Application No: 2016/92029

Proposal: *Erection of extension to existing Kingsgate Shopping Centre to form new Leisure Development including new cinema and restaurants, and demolition of existing buildings on the site including 20-22 Cross Church Street (partly within a Conservation Area)*

Location: *Proposed development site comprising, 20-22, Cross Church Street, Fleece Yard, Sun Inn Yard and White Lion Yard, Huddersfield, HD1 2TP*

Recommendation: *For Members to note the content of the report and respond to the questions asked*

STAGE 1 - Original Proposed Elevation

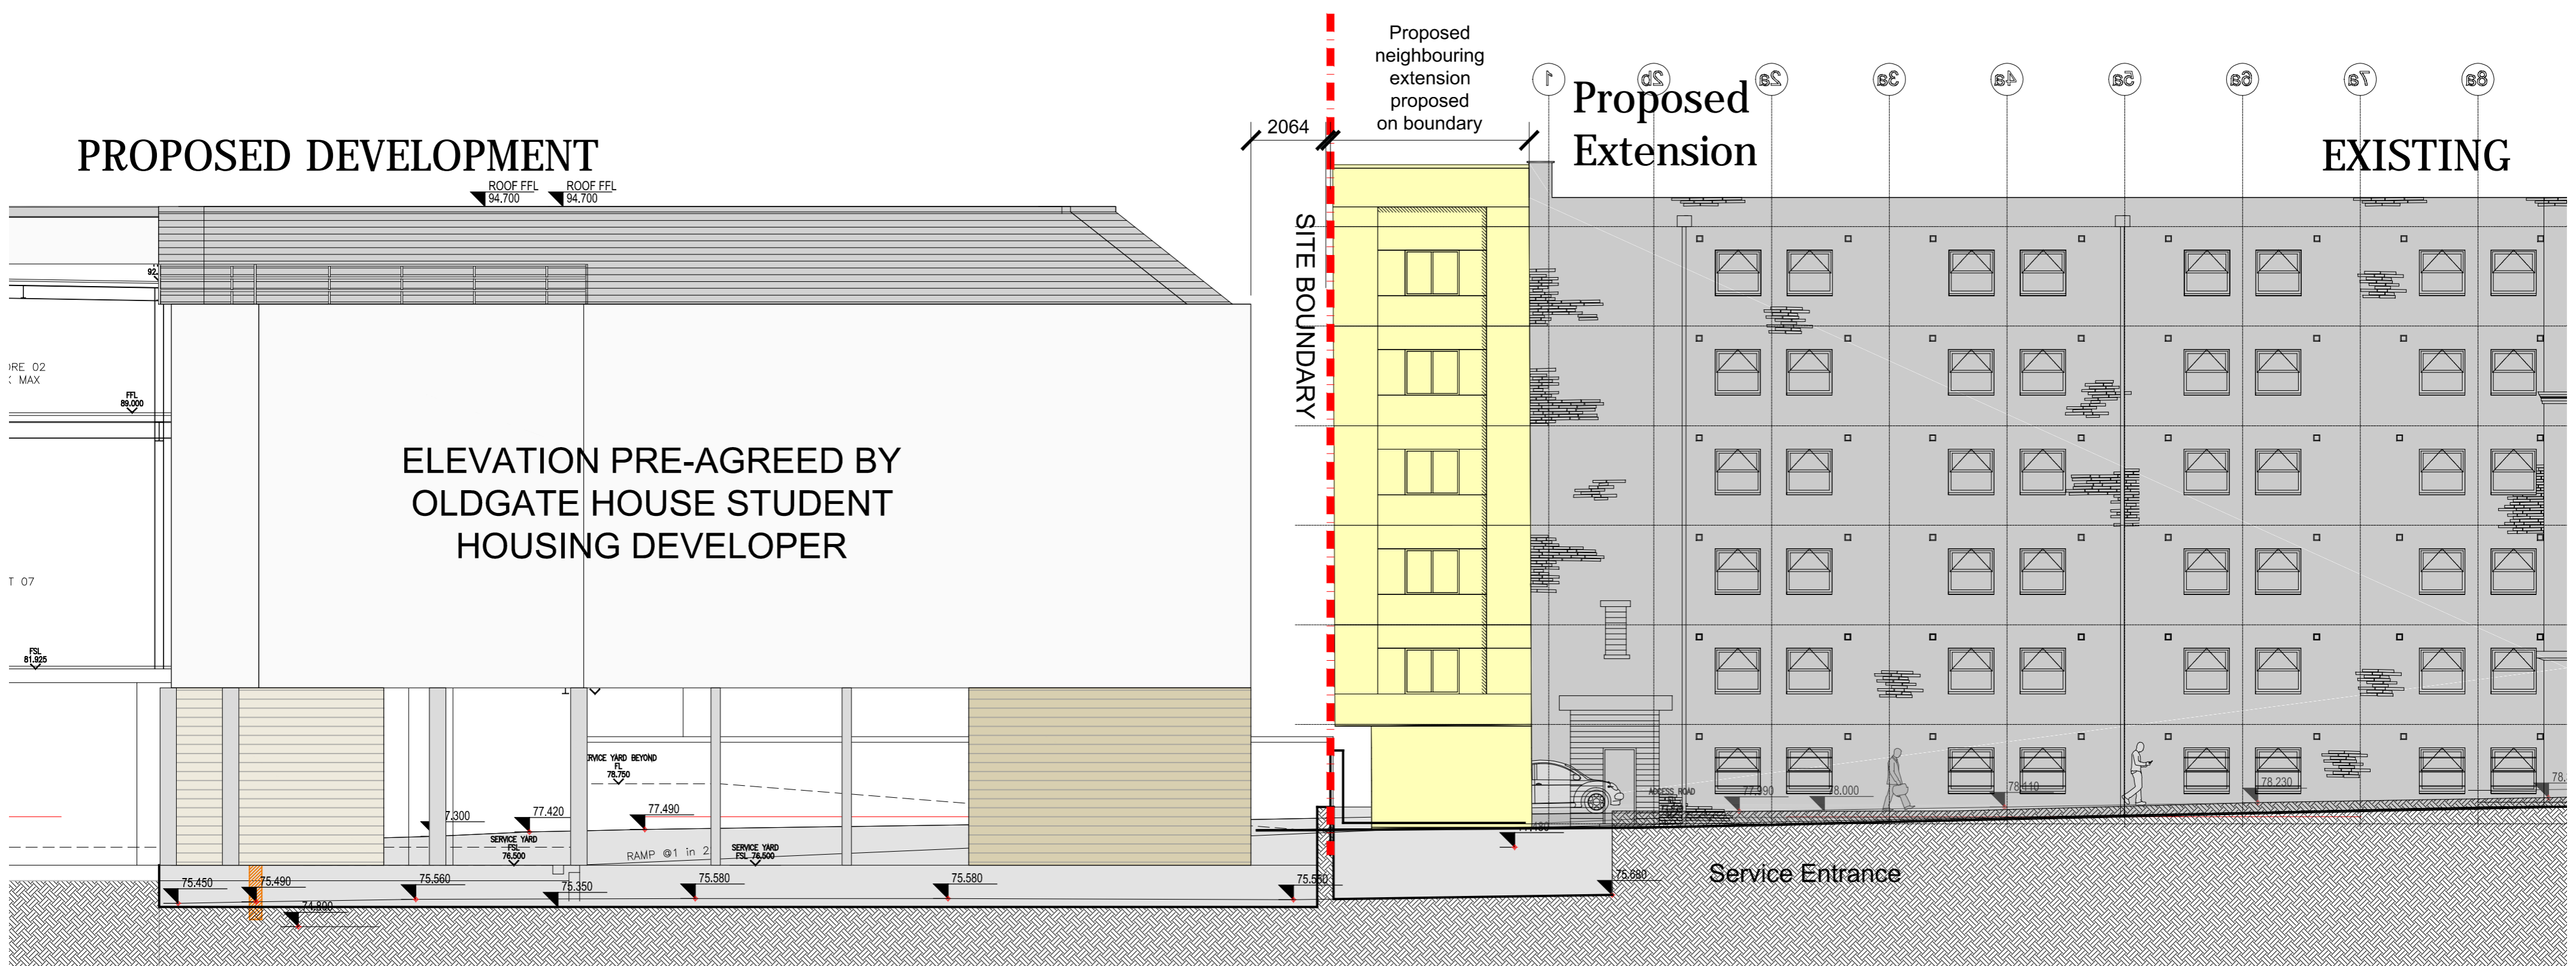
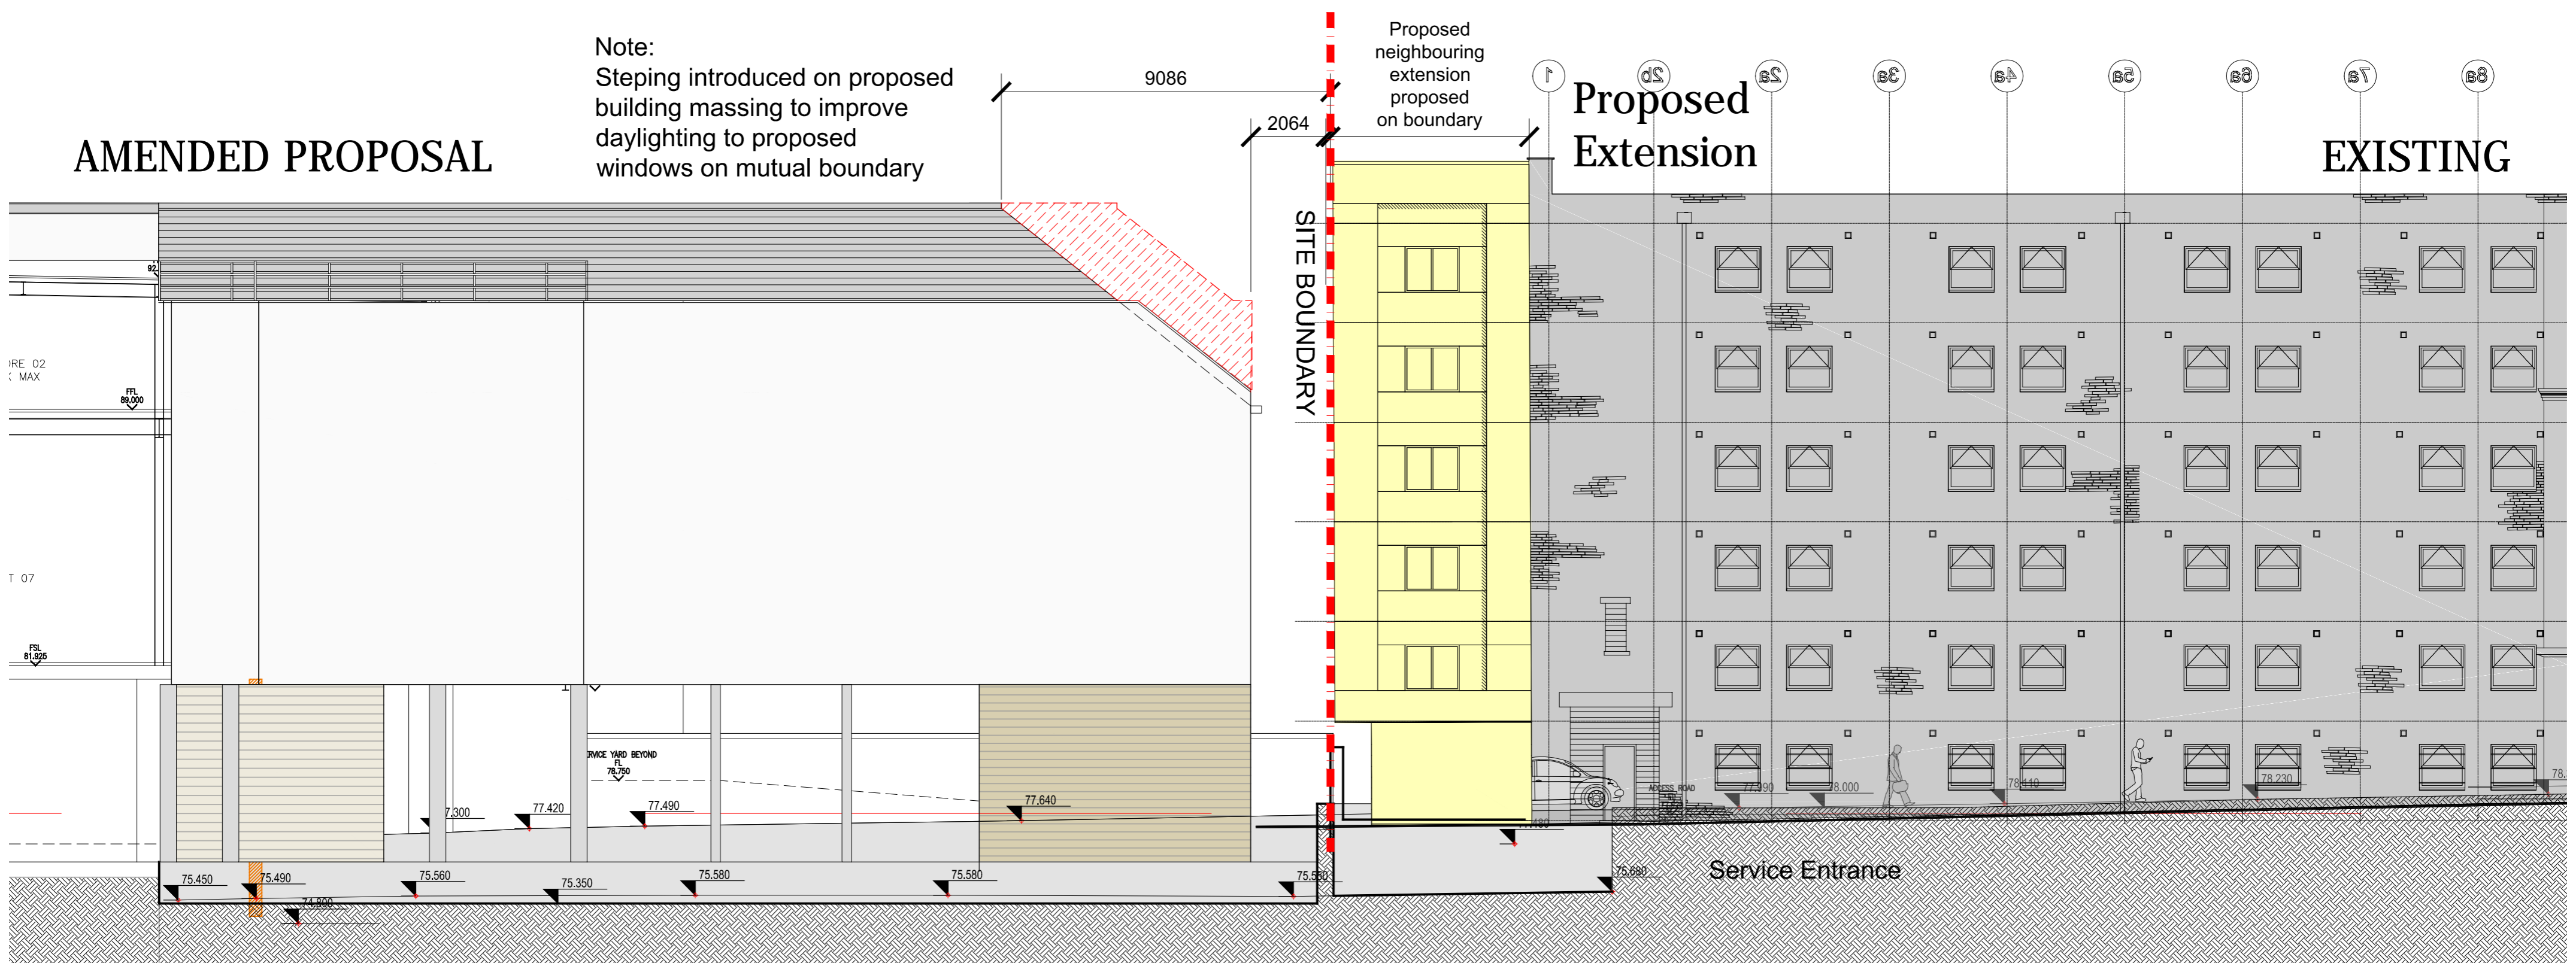
Officers have undertaken negotiations with the applicant to secure a reduction in the height of the building. The revised elevations show a significant reduction in height of 4.1 metres, and the benefits of this in respect of visual amenity and the impact on heritage assets is clearly shown in the Visual Impact Assessment provided.

1. FRONT ELEVATION

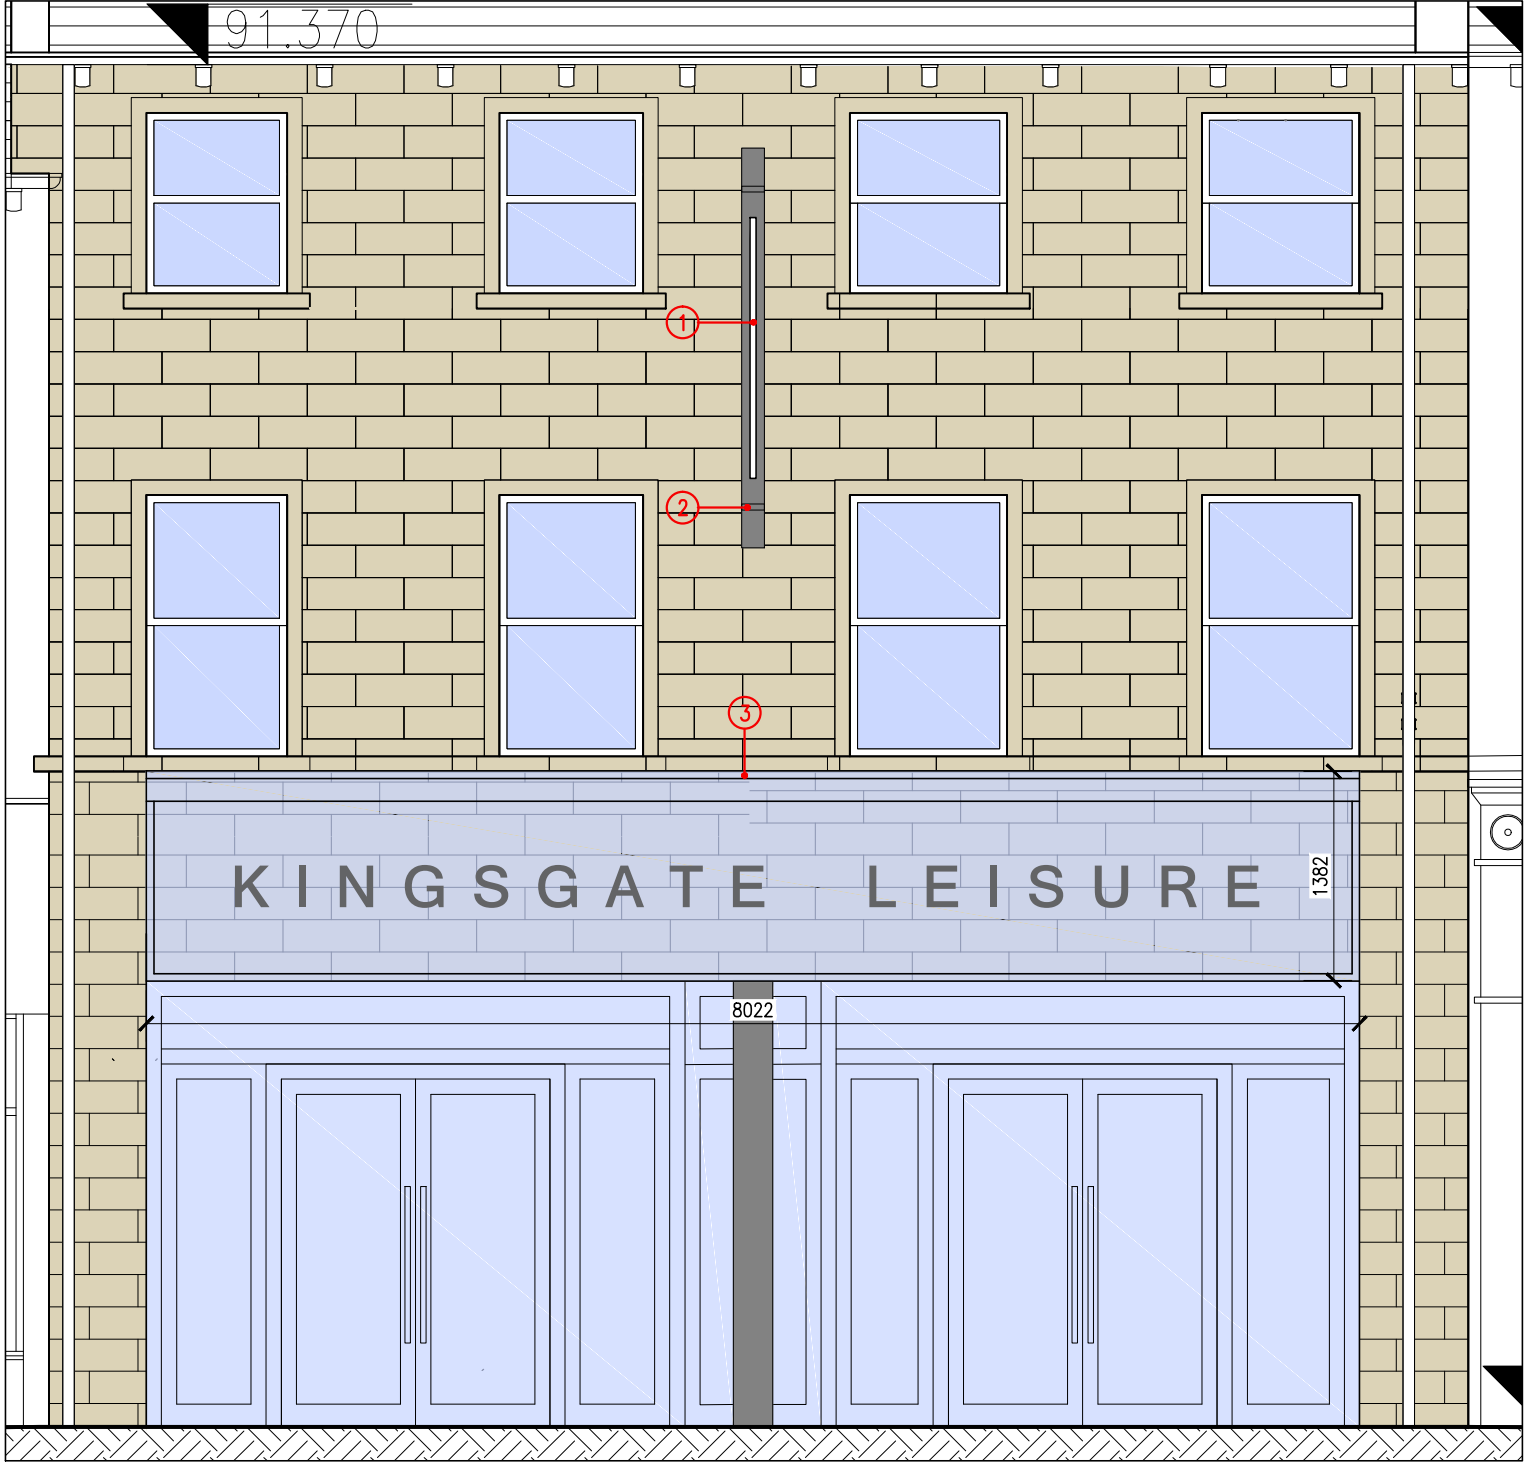
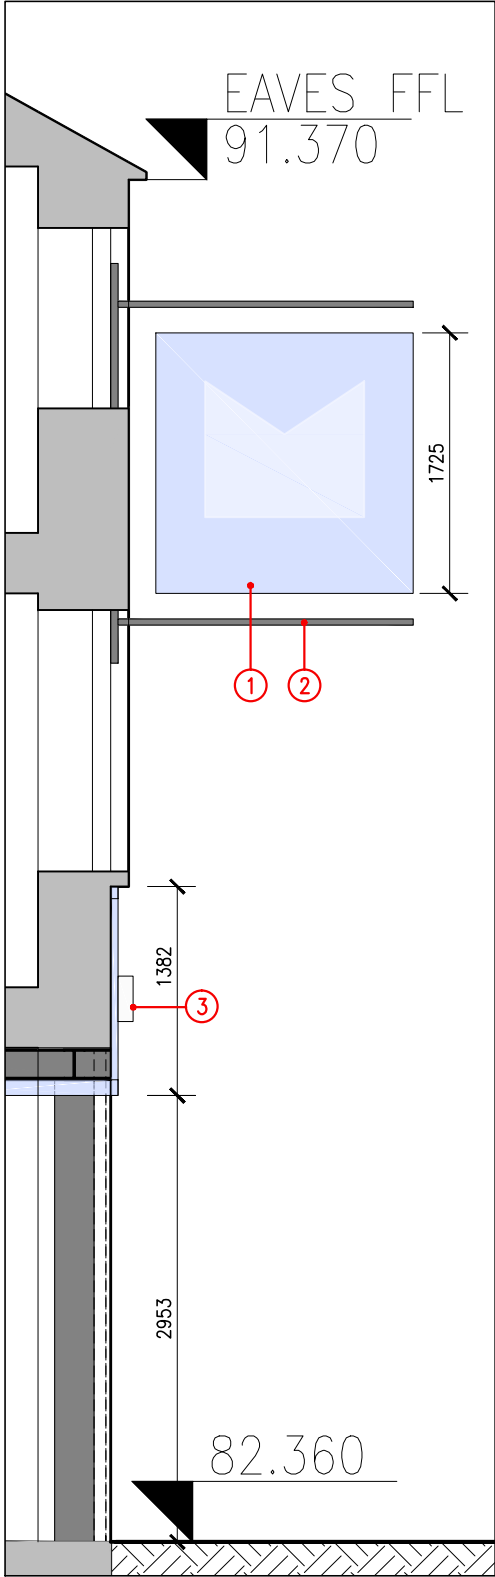
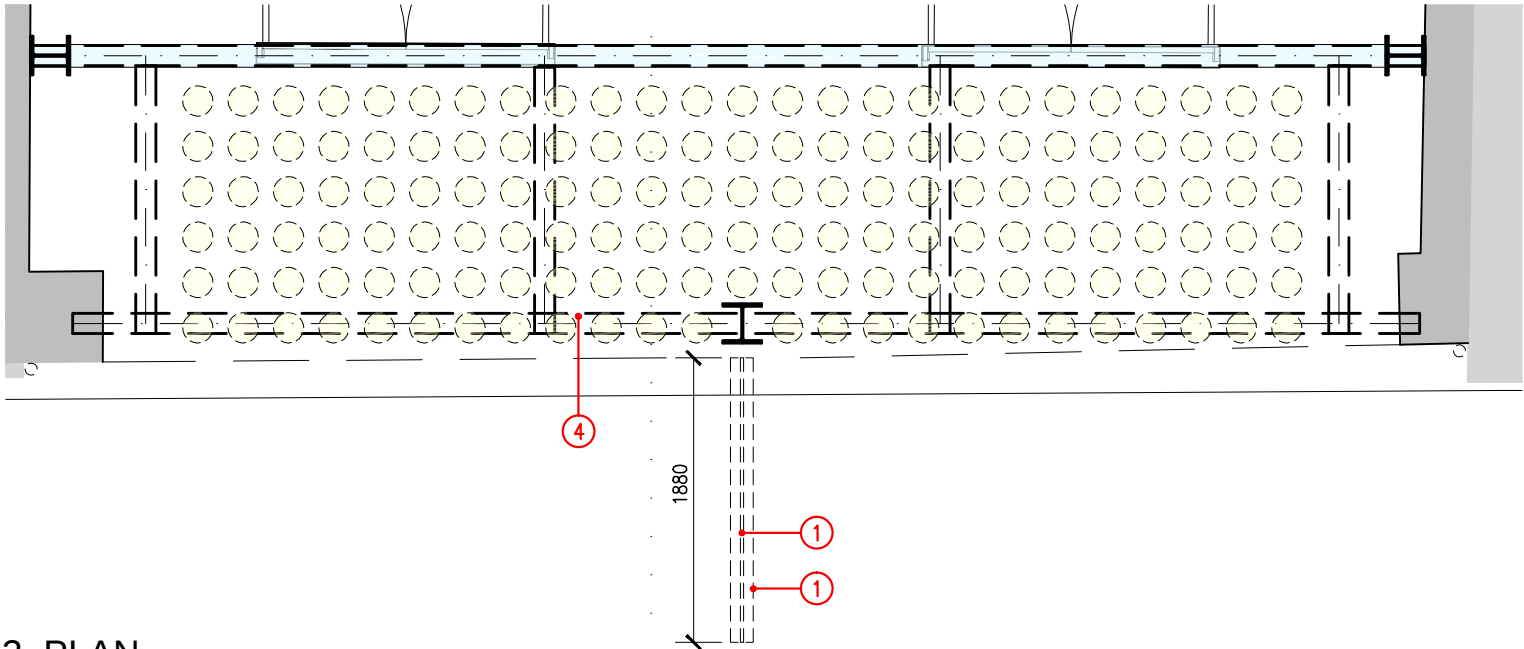
They have raised concerns however, regarding the removal of the first floor to create the mall entrance, and the bridge linking to one room on the second floor of 20 Cross Church Street. The latest revised plans seek to overcome this concern by retaining the ceiling above the ground floor and removing the glazed link at the upper floor. Historic England are being consulted on these latest revisions and committee will be updated on the progress of these discussions. There is concern there is limited information as to how the structures will be adequately supported. There is still also concern about the extension of the frontage into Cross Church Street with the formation of a canopy and totem signage, which could obscure views of the listed buildings,

including St Peters Church and the contribution 20-22 Cross Church Street make to the historic streetscape. The applicant is seeking to address these matters.
